From: Planning\_THM <Planning\_THM@environment-agency.gov.uk>  
Sent: 06 January 2023 15:09  
To: Planning; James Kirkham  
Subject: RE: Planning notification for application reference: 22/01682/F  
Attachments: eCon\_(3).pdf

**Development of a Ground Mounted Solar Farm Incorporating The Installation Of Solar PV Panels, Associated Infrastructure and Access, as well as Landscape Planting and Designated Ecological Enhancement Areas**  
**Land North Of Manor Farm, Noke**  
**Our ref: WA/2022/129953/01-L01**  
**Your ref: 22/01682/F**

Title:
PV Module Elevation
and Cross Section

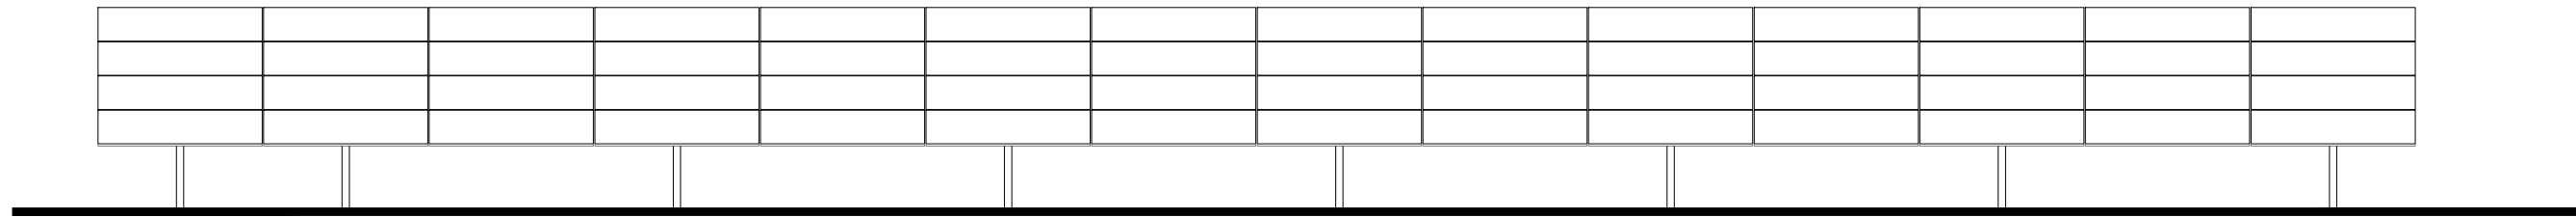
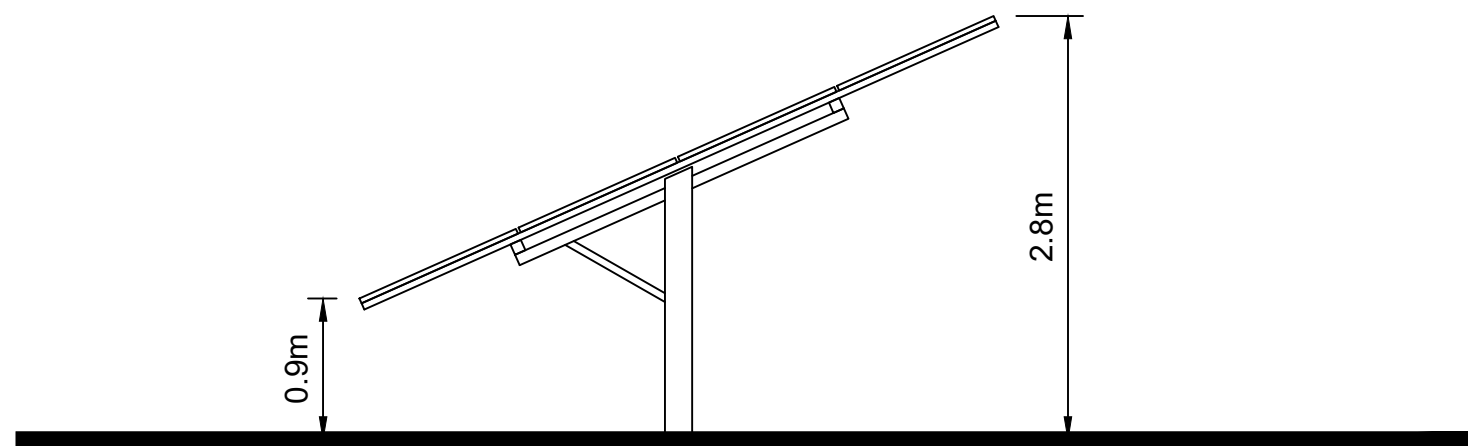
The report states that all essential infrastructure will be located in Flood Zone 1, i.e. outside the calculated design flood extent. It also states that the solar panels will be set at least 0.9m above ground level in the areas affected by fluvial flooding.

Section 8.0 of the Flood Risk Assessment produced by Nijhuis Industries ref J-14174 Edition 04, dated September 2022 acknowledges the potential impact the piles supporting the panels could have on flood flows where they are located in the design flood extent and states they will be sufficiently spaced to minimise flow disruption. There does not appear to be any assessment of cumulative impacts on floodplain storage in the report. Please provide a quantitative assessment of the impacts of this solar panels on floodplain storage and flood flows, and if necessary any proposed mitigation measures.
